**From:** Adams, Wayne <AdamsW@wsdot.wa.gov>  
**Sent:** Thursday, January 28, 2016 2:24 PM  
**To:** Jeff Watson  
**Cc:** Holmstrom, Rick  
**Subject:** SUB15-00007 Riste Short Plat Comments  
**Attachments:** KittCo\_RisteShortPlat.pdf

Subject: SUB15-00007, Riste Short Plat  
SR 821, MP 6.0 vicinity

We have reviewed the proposed project and have the following comments.

DRAWING TYPE: SHORT PLAT APPLICATION

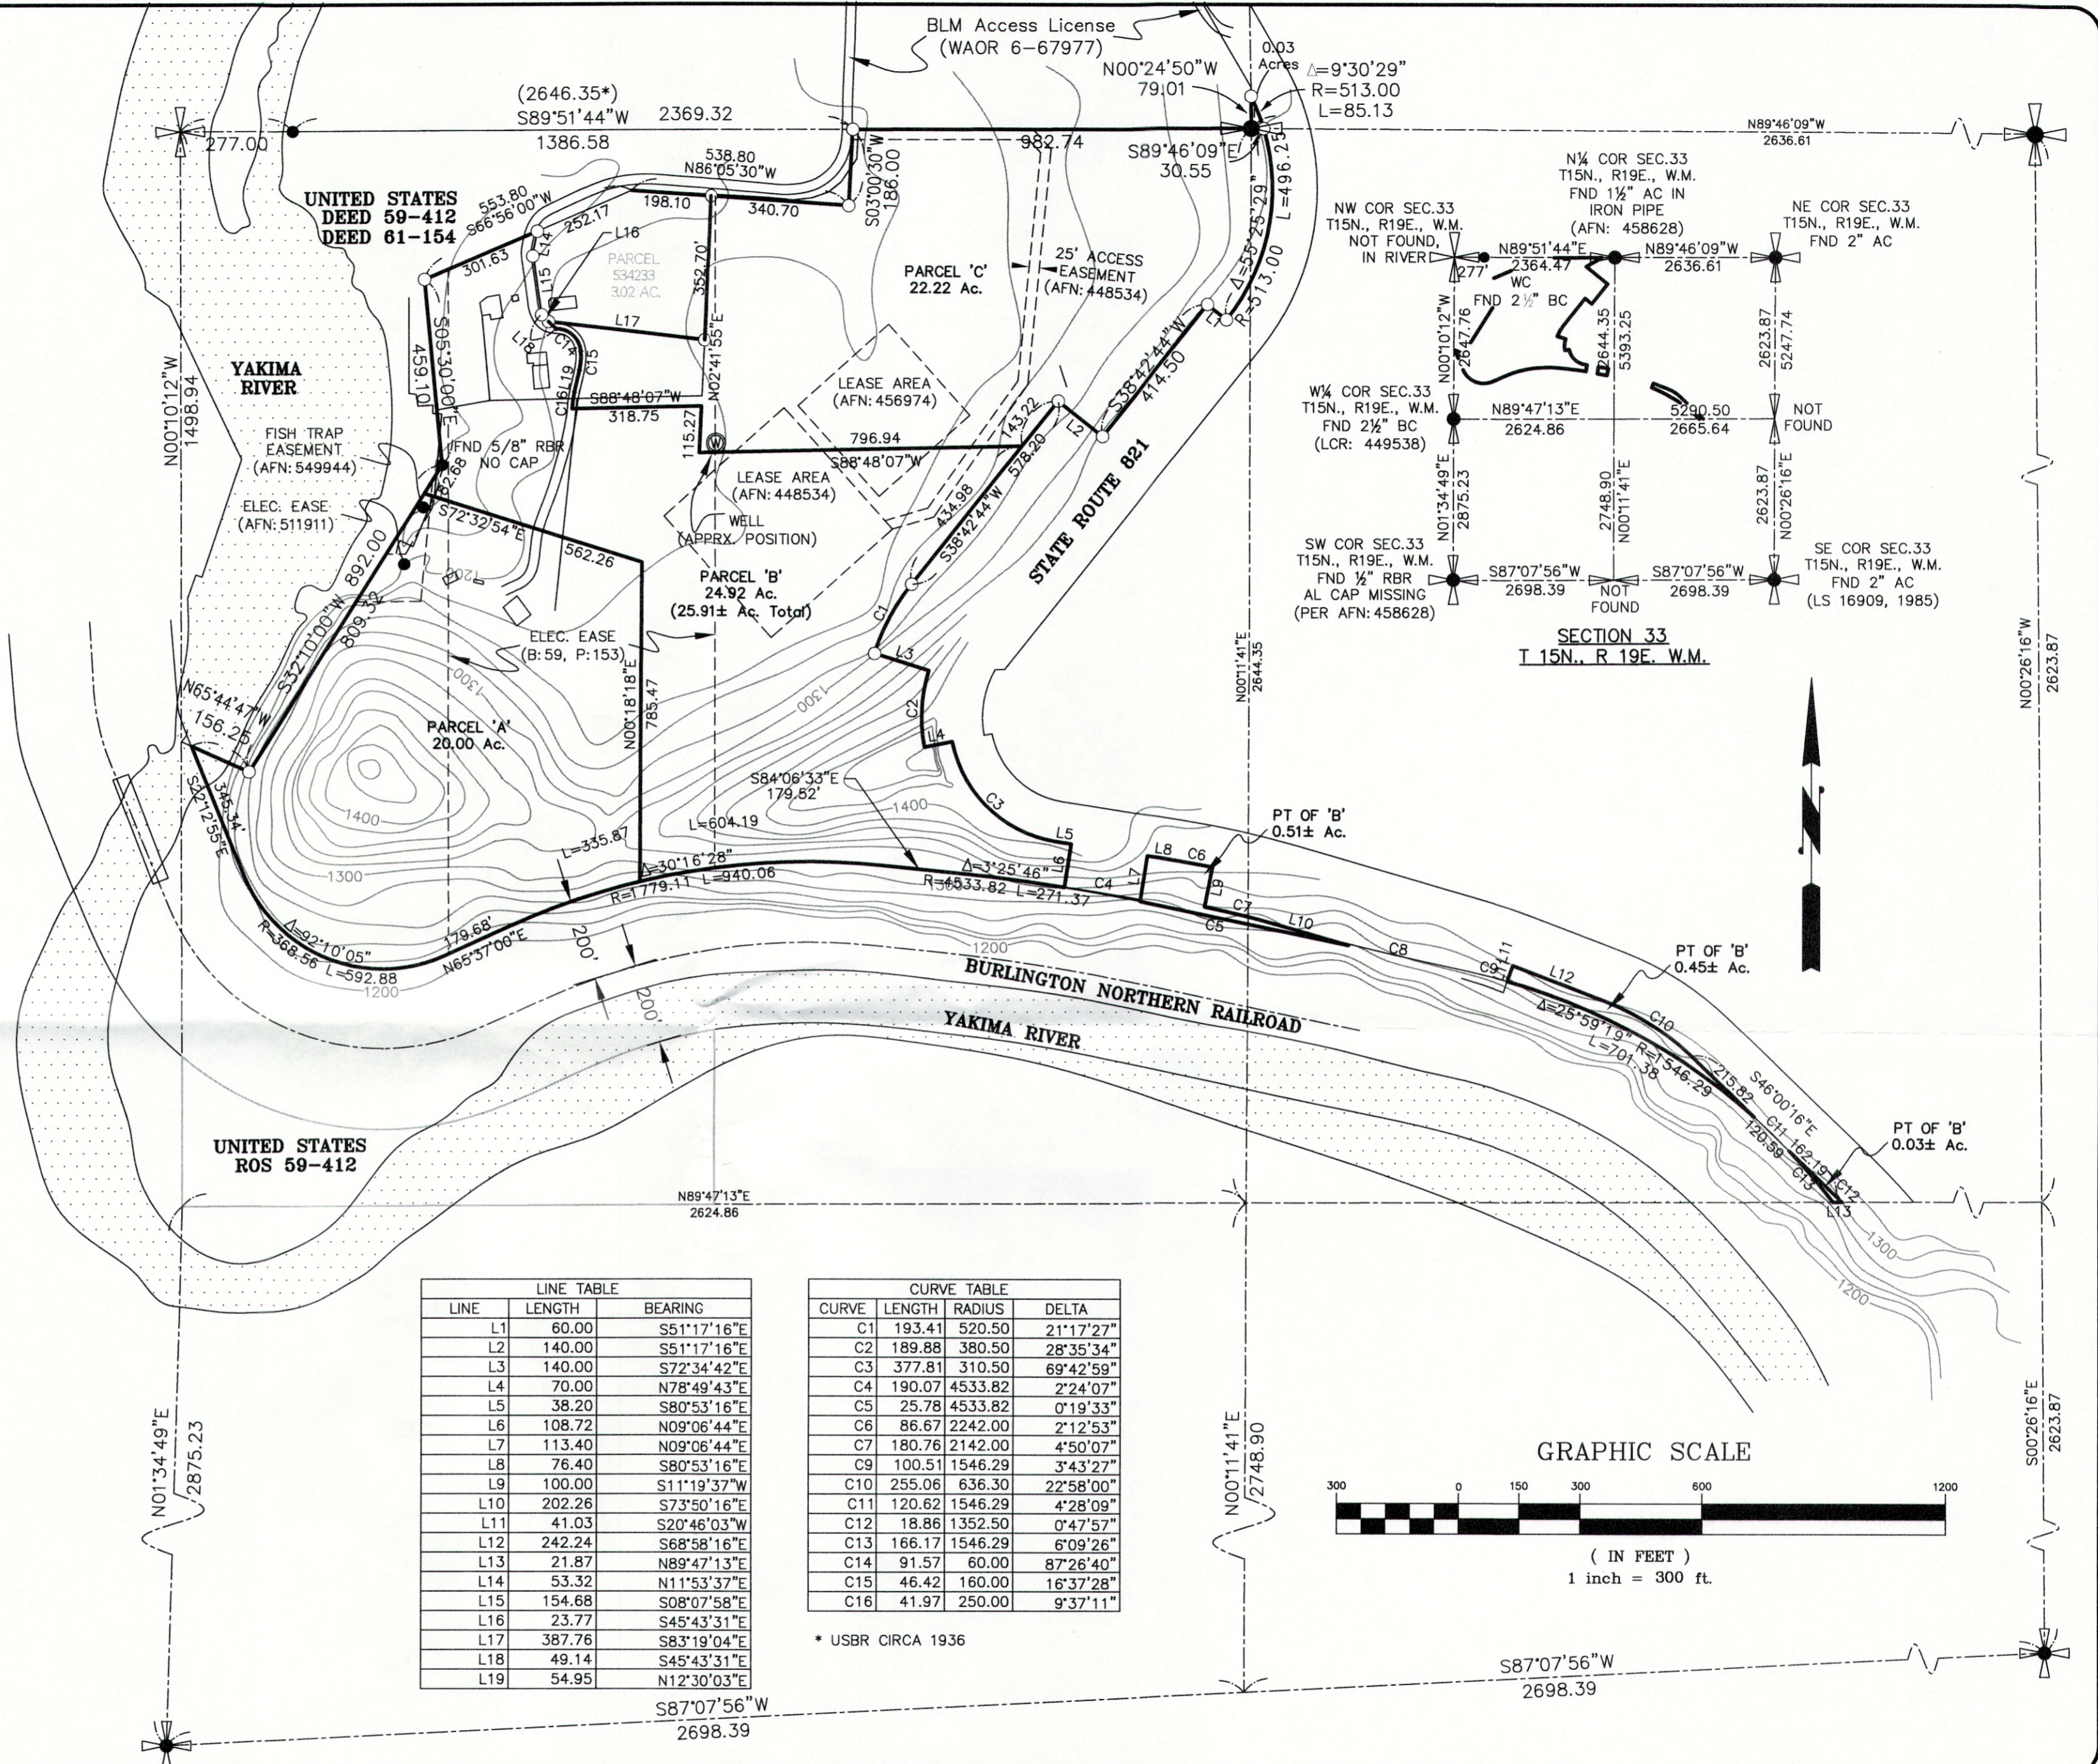
- The subject property is adjacent to State Route 821 (SR 821). This segment of SR 821 is a Class 3 managed access highway with a posted speed limit of 45 miles per hour. There is an existing grandfathered approach at approximate MP 6.26 and a permitted approach at MP 6.20. According to the short plat, all access will be via the existing approach at MP 6.26. The approach at MP 6.26 will be for the newly created parcels, BLM access, and parcel # 534233. The proponent is required to remove the approach at MP 6.20. Proponent should also contact Mark Kaiser at 509-577-1668 to update the current access connection permit
